Your Ref: EN070001  
Our Ref: YHPL-AFP006

## **YORKSHIRE AND HUMBER CCS PIPELINE**

### **THE EXAMINING AUTHORITY'S (EXA'S) FIRST WRITTEN QUESTIONS AND REQUESTS**

#### **RESPONSE FROM NORTH YORKSHIRE COUNTY COUNCIL (NYCC)**

**BARMSTON PUMPING STATION  
 PARAMETER PLAN**

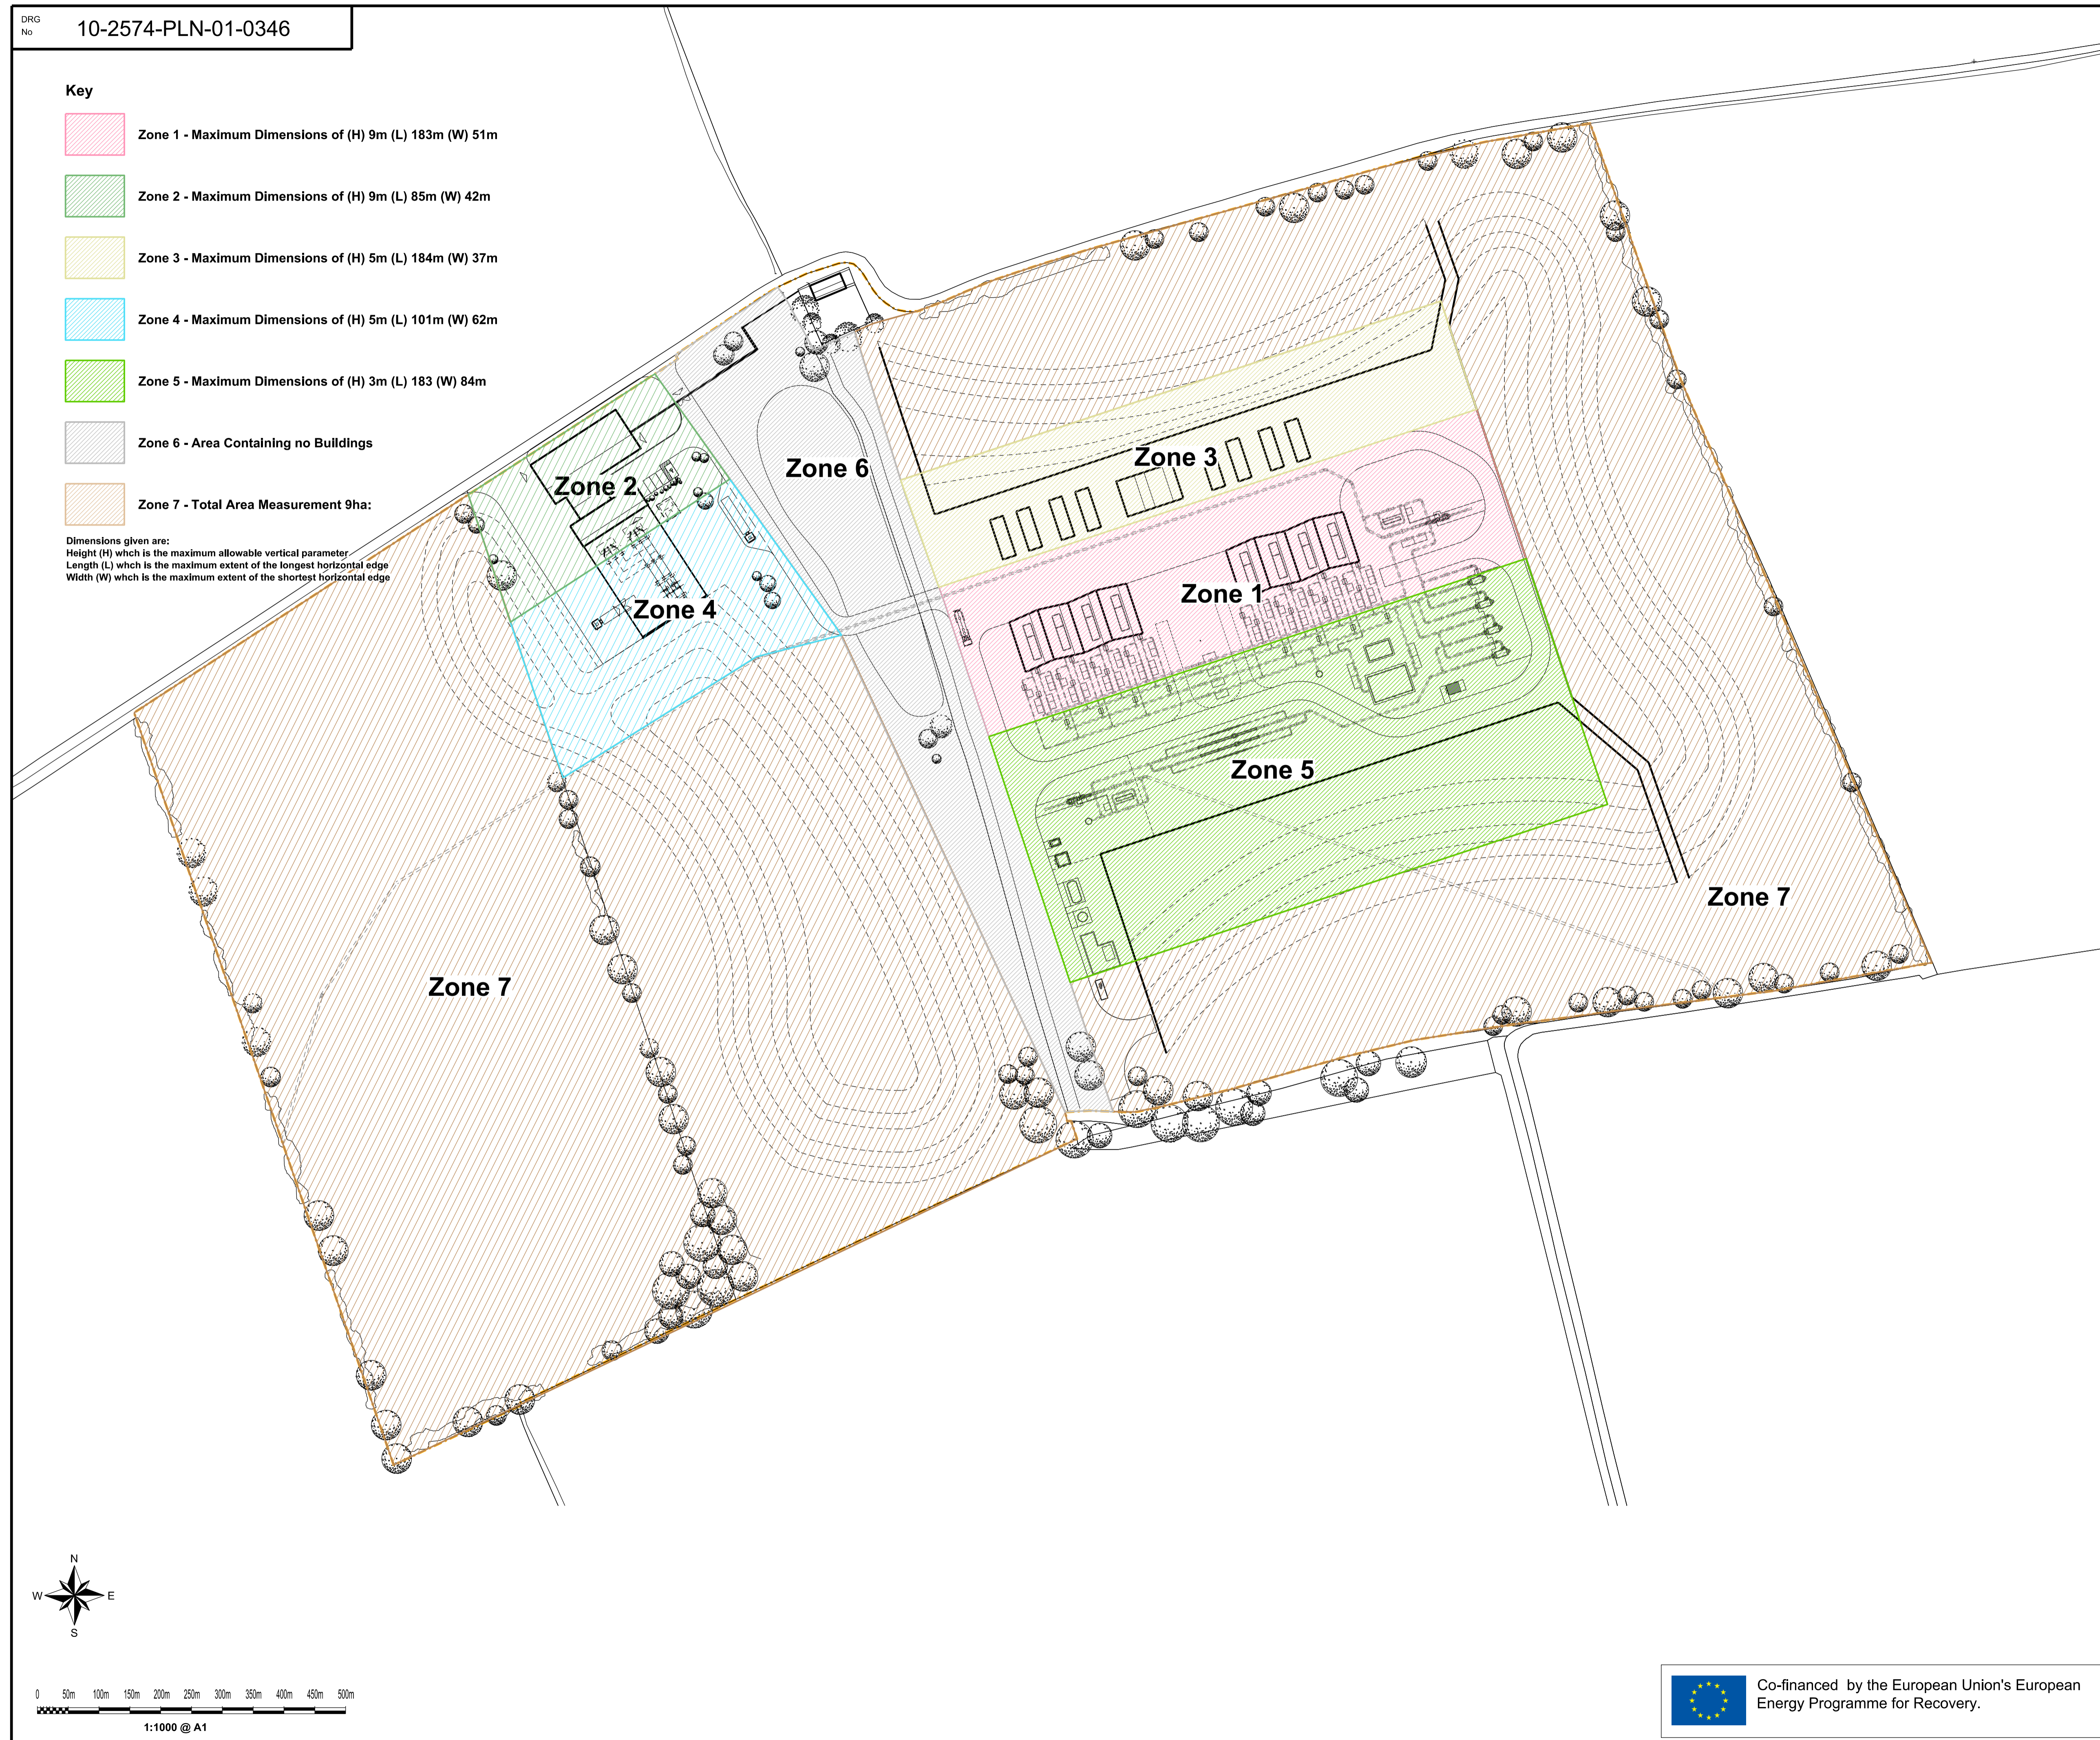
**Q1.13 – It is noted that Area B of the Camblesforth multi-junction (an outline area providing capacity for a further three PIG Traps that would be needed to accommodate future connections to the pipeline but will be grassed in the meantime (para 4.2.1 of ES Chapter 3)) and Barmston pumping station are being applied for at outline level. Parameter plans have been produced for each of these project components which include the maximum dimensions of buildings. Can the applicant and local planning authorities consider whether the DCO is sufficiently detailed for these components and how would these “reserved matters” be controlled?**

From the landscape perspective, the DCO information is adequate for Area B, but the unknown factors are the three potential pipeline routes which they would serve, for which no information is available. It is questioned why the PIG traps need to be dealt with as reserved matters, rather than be part of future NSIPs dealing with future pipeline applications?

TITLE
DRAX PIG TRAP
TEMPORARY CONSTRUCTION
VEHICULAR ACCESS (NEW ROAD)
VEHICULAR SWEEP PATH ANALYSIS
APFP REGULATION 5(2)(0)
PINS REFERENCE NO. EN070001
DOCUMENT REFERENCE 2.64

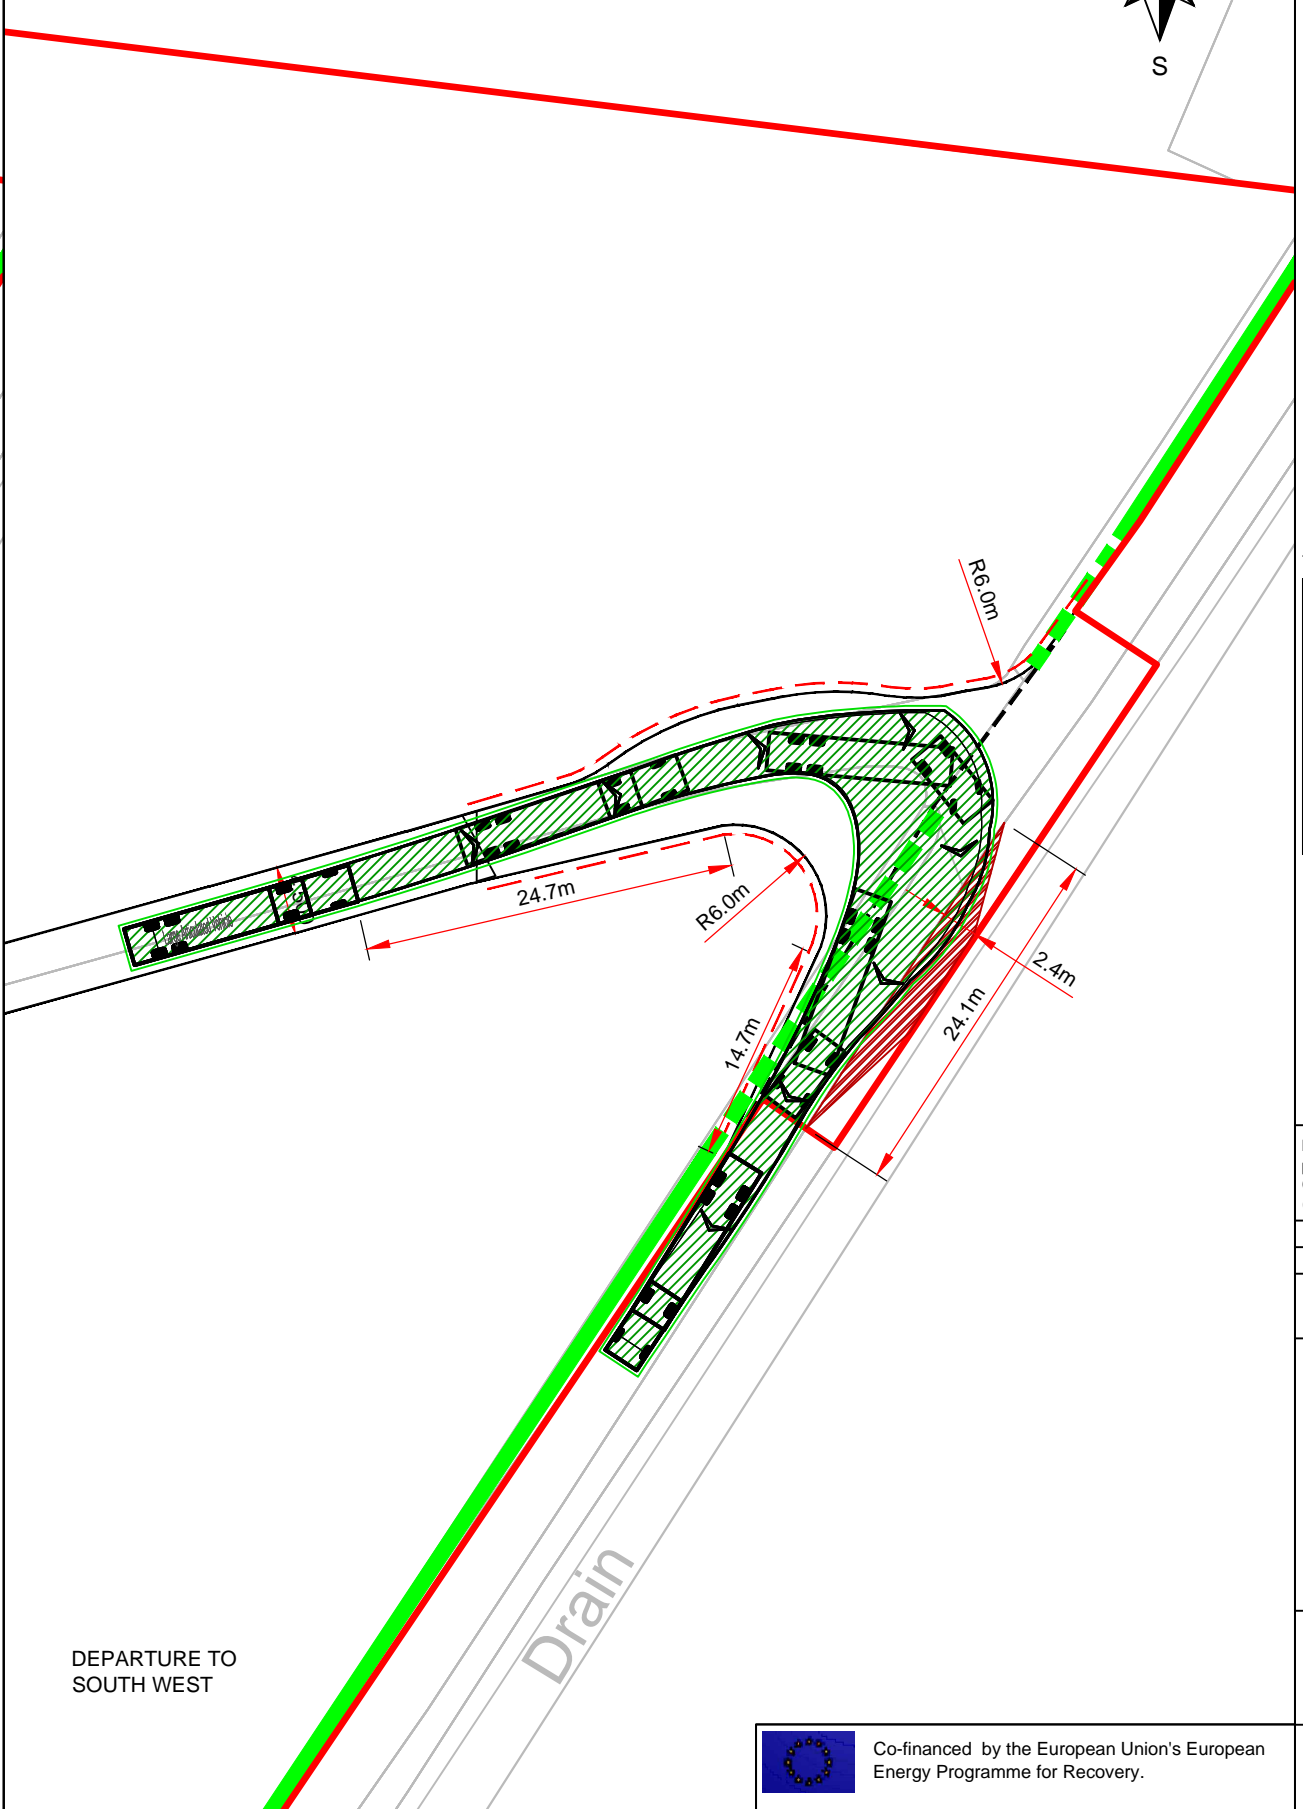
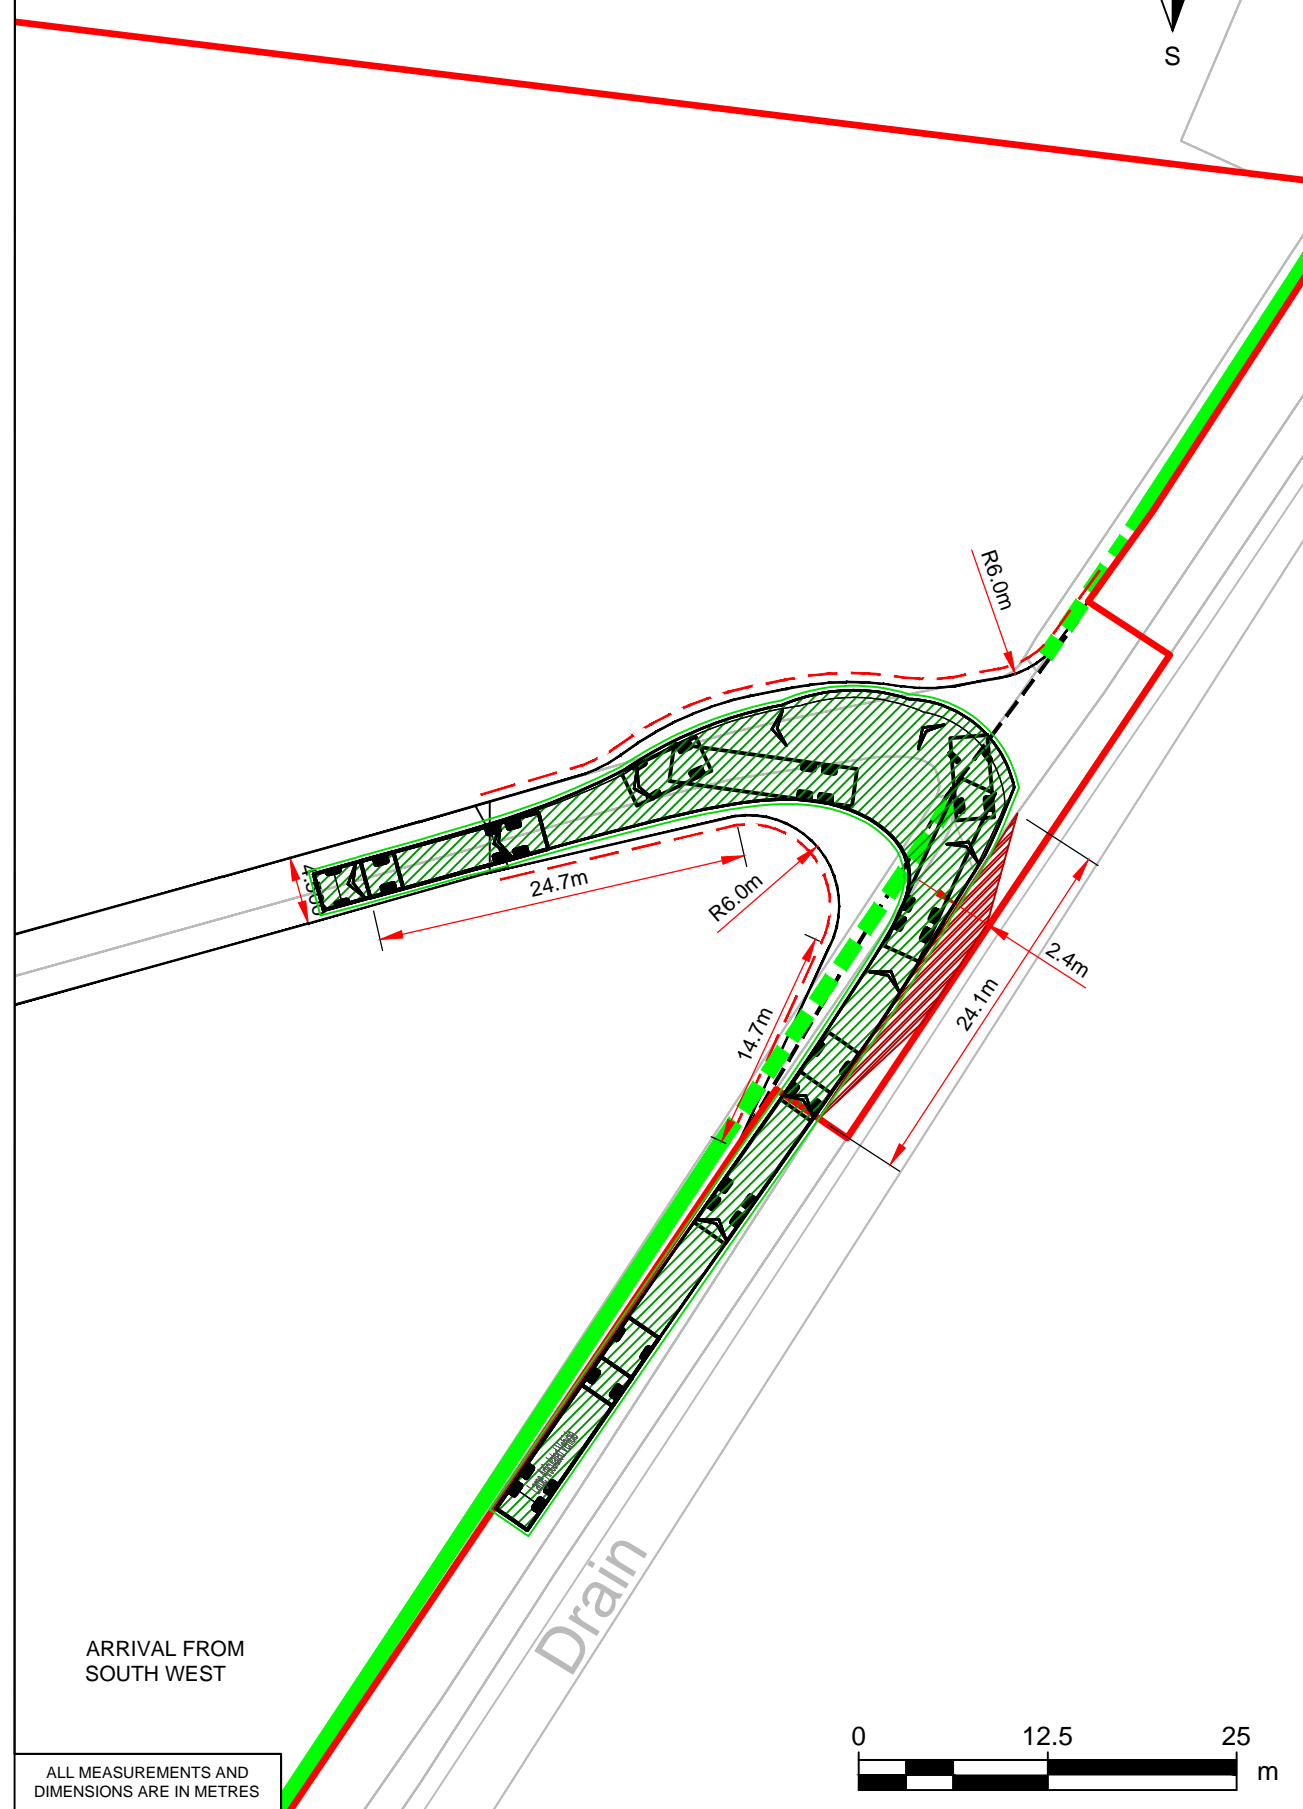
It is considered by NYCC that the Drax Pig Trap will adversely impact on the legibility of the historic landscape setting of the former Drax Abbey (also known as Drax Augustinian Priory) site which partly overlaps with Drax Abbey Farm steading. A country house named Drax Abbey, adjacent to the farm, was demolished in 1953, but gardens, orchards and trees were associated with it, including trees still present. The setting of the Drax Abbey site and Drax Abbey Farm and their approach along Pear Tree Avenue (formerly Ave Maria Lane as shown on the 1<sup>st</sup> edition OS map) would be compromised by construction of the pipeline to west, north and east of the site, and the temporary construction area to the south.

The mature trees on the Drax Abbey/Farm site and along Pear Tree Avenue are of landscape value despite the presence of the nearby power station, and the landscape setting is locally sensitive because of the historic associations (although the LVIA para 9.6.2 does not recognise it as having any particular importance). The proposed Drax Pig Trap site reduces the existing buffer of open agricultural land that preserves something of the Abbey and farm's former isolation, as viewed from local roads and PROW. Due to the presence of new industrial infrastructure and security fencing, the PIG Trap site will add to the perception of urbanisation.
